605 Stevens Ave - Code

Thank you for taking the time yesterday to discuss the issues with the code for the 605 Stevens Ave/Motherhouse project. I understand that this building is quite complicated and atypical and I will work diligently until we are all comfortable with the arrangement and the code compliance.

A0.03

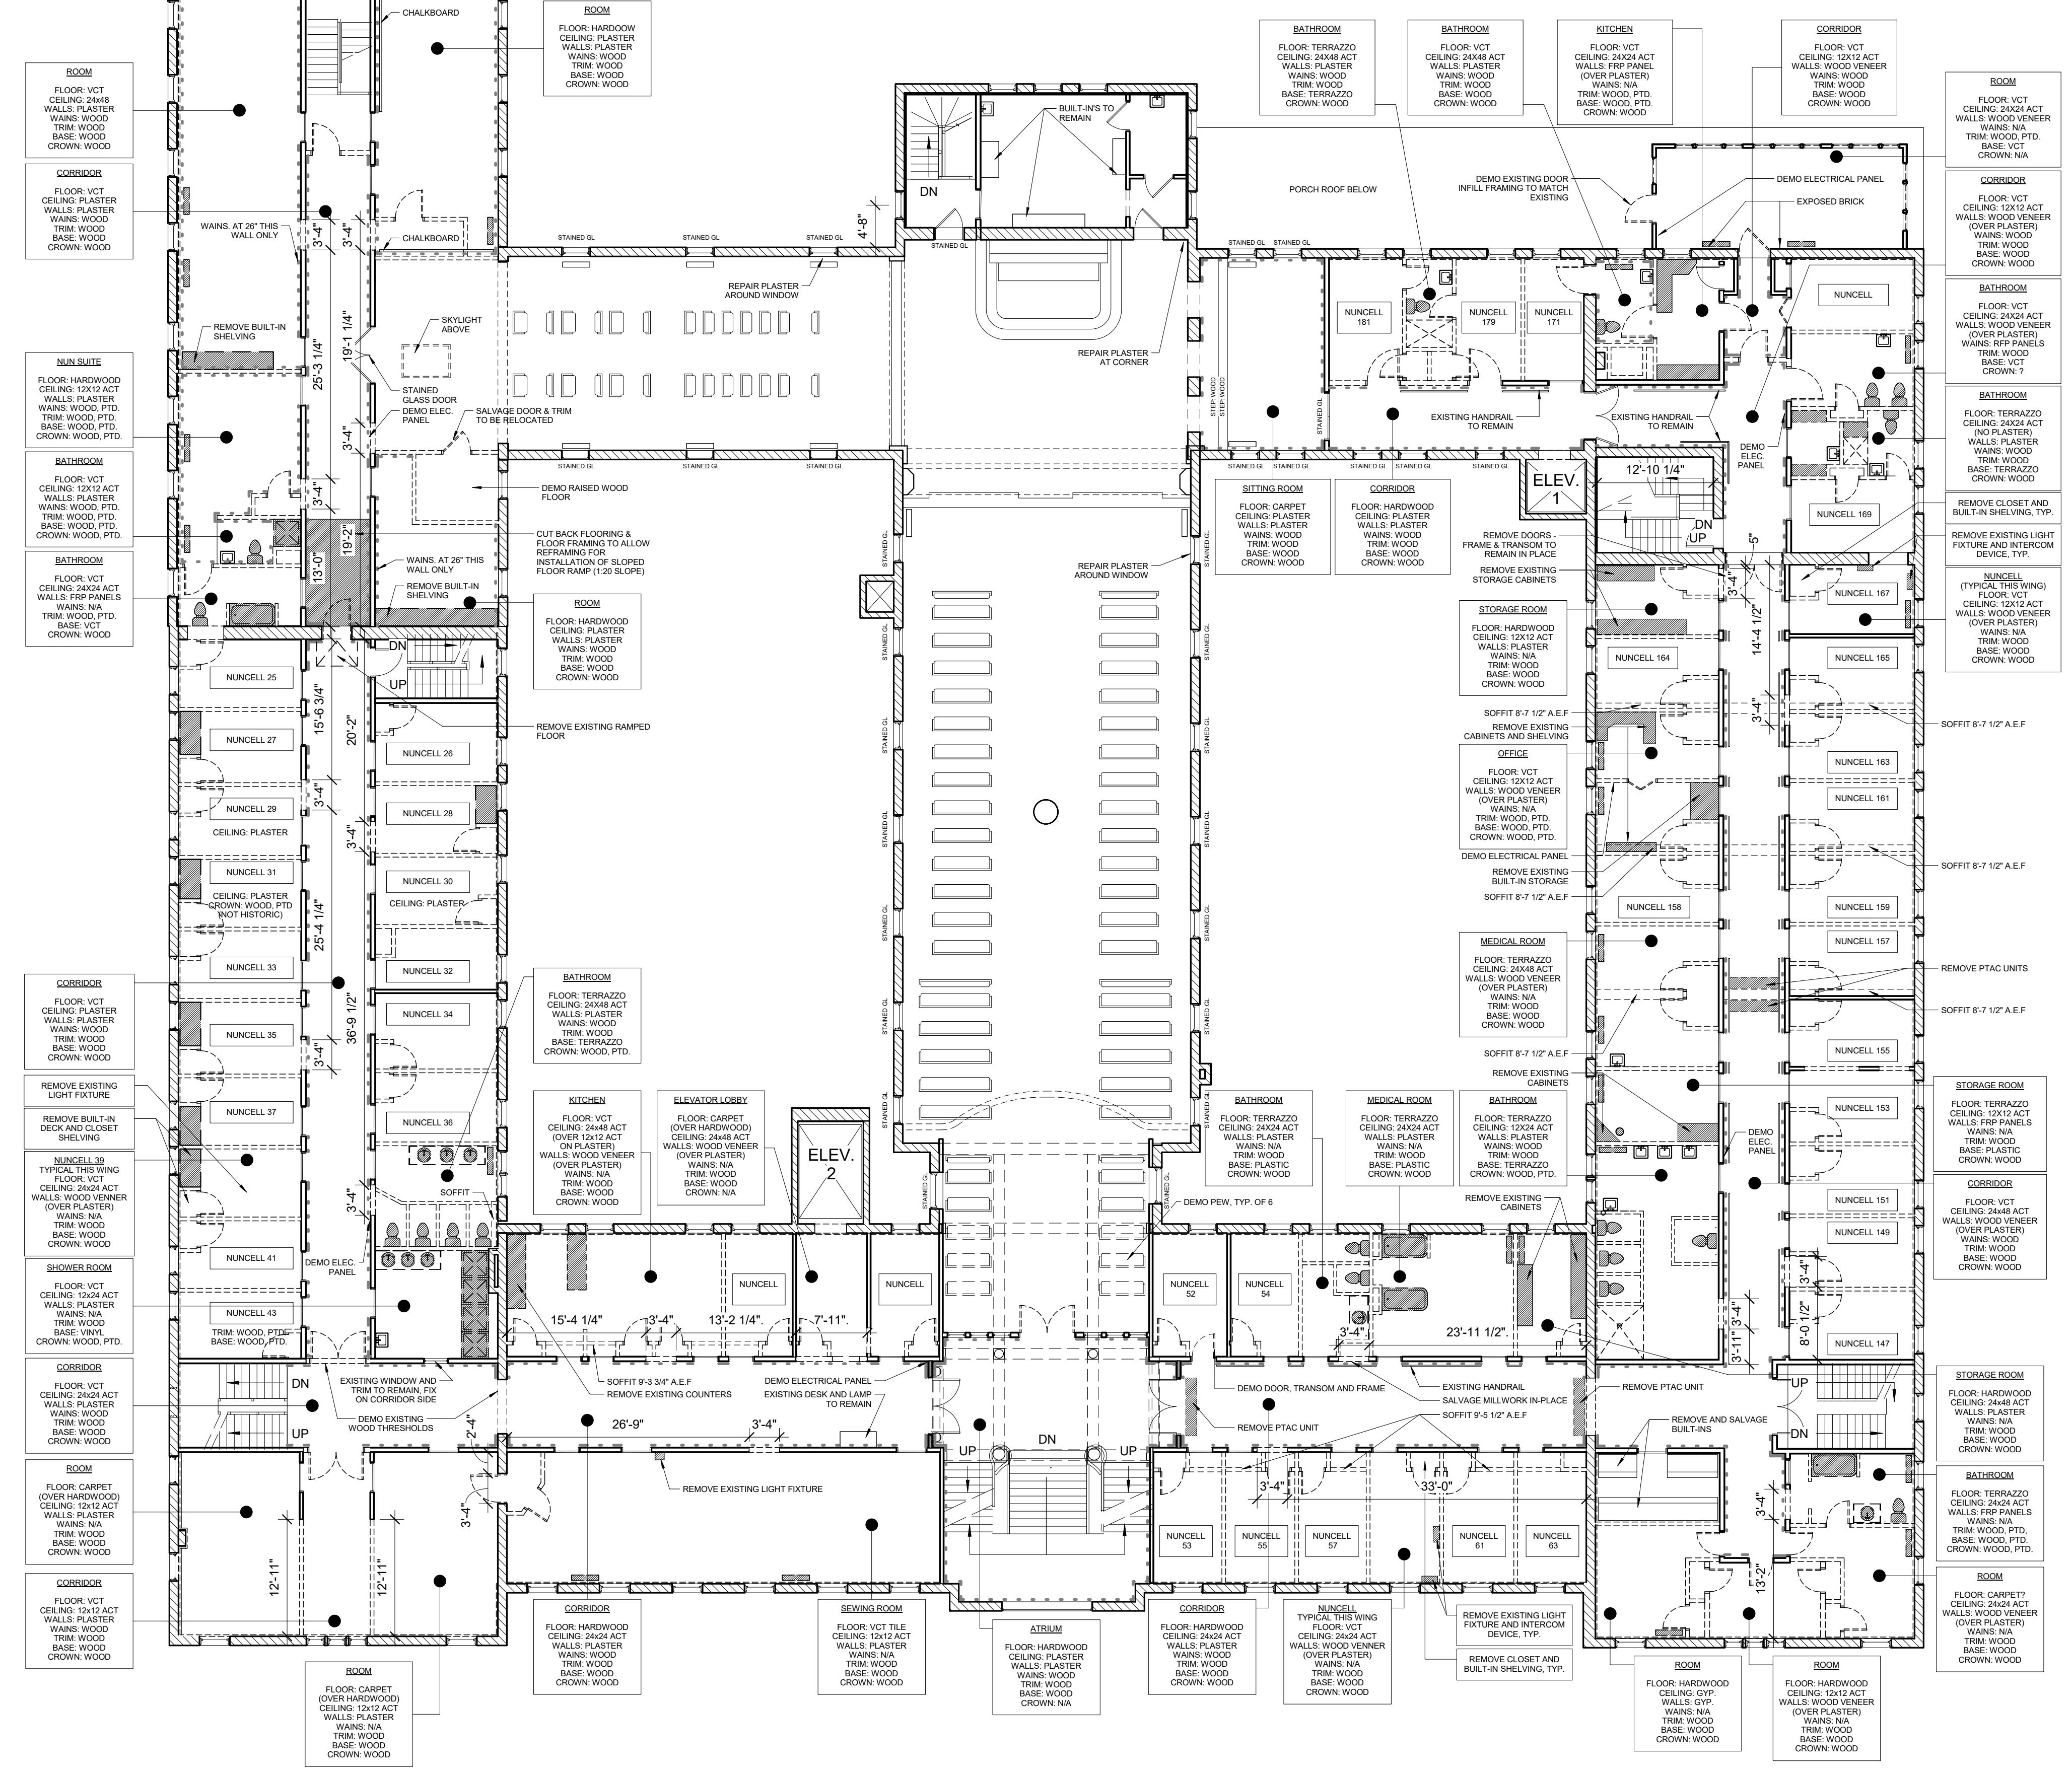
With regards to the assembly occupancy, the chapel, on the third floor I will try my best to lay out my interpretation of the NFPA codes as they apply and we can discuss this interpretation going forward. Bear with me, please, as this is not short or quick.

To me, this says that the assembly space on floor 3, regardless of what is stated in Table 13.1.6, is permitted to remain on floor 3 so long as we all agree that this does not constitute a distinct life-safety issue – something which I will address below.

This statement is self-explanatory, as I see it. We are in no way diminishing the life safety features of the facility. On the contrary, by enclosing the stair shafts in new rated construction, we are *increasing* the life-safety features. We are not increasing the floor area in any way, so the occupant load will remain unchanged.

**LS1.2**

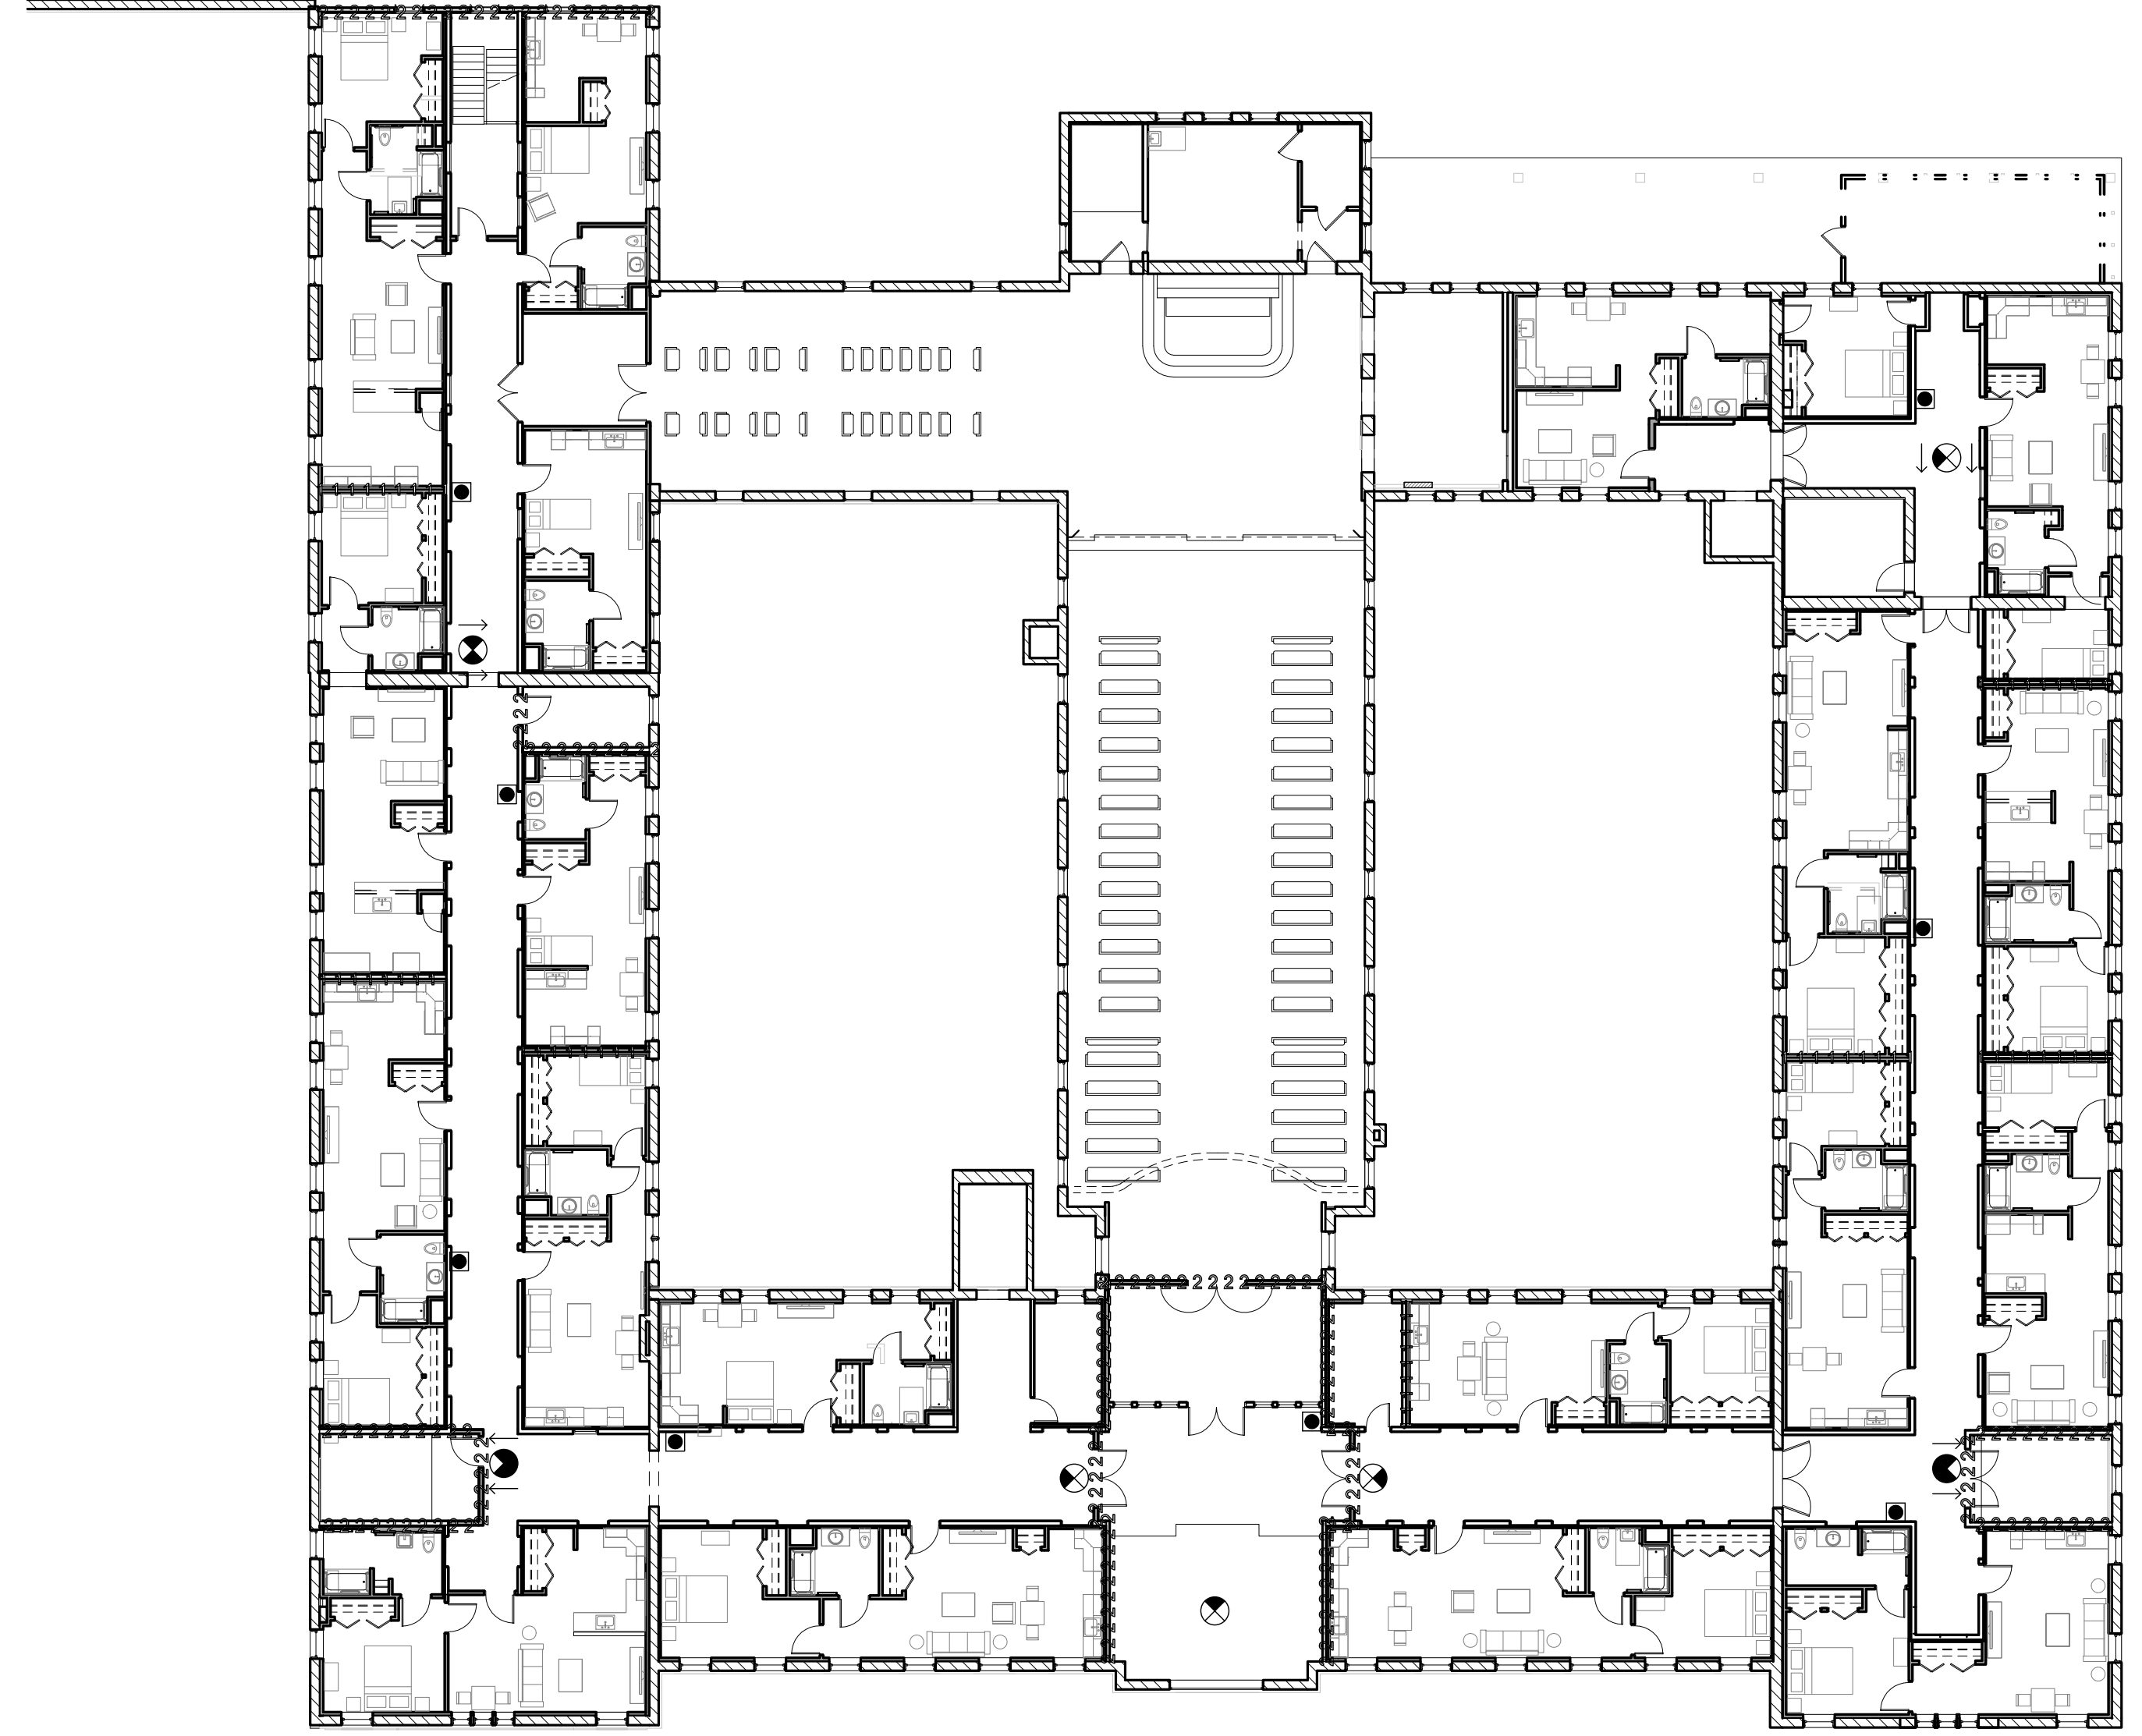
When Craig and I did the walk through, there was some discussion as to the use of the assembly space. This remained rather unclear after we asked this. Could you remind me of the proposed use?

One other question is the pews. Would they remain existing? Directly, what I am getting at is the occupant load. Can you tell me the existing OL, and what would be the possible OL?

The fourth floor is listed as assembly. I would be comfortable with calling this incidental to the assembly, with the condition of the organ staying. This could open a can of worms in the future if we don't place conditions on it. Any suggestions or ideas?

The current occupant load, based on 15 sq.ft./person is 339. As discussed, it would not be a problem for us to have you post the occupant load at 299, to keep it below the NFPA threshold for occupants found in Table 13.1.6, X4, when dealing with building height.

I totally agree. The organ is definitely staying, so the maximum occupant load up there is really about 2 or 3.
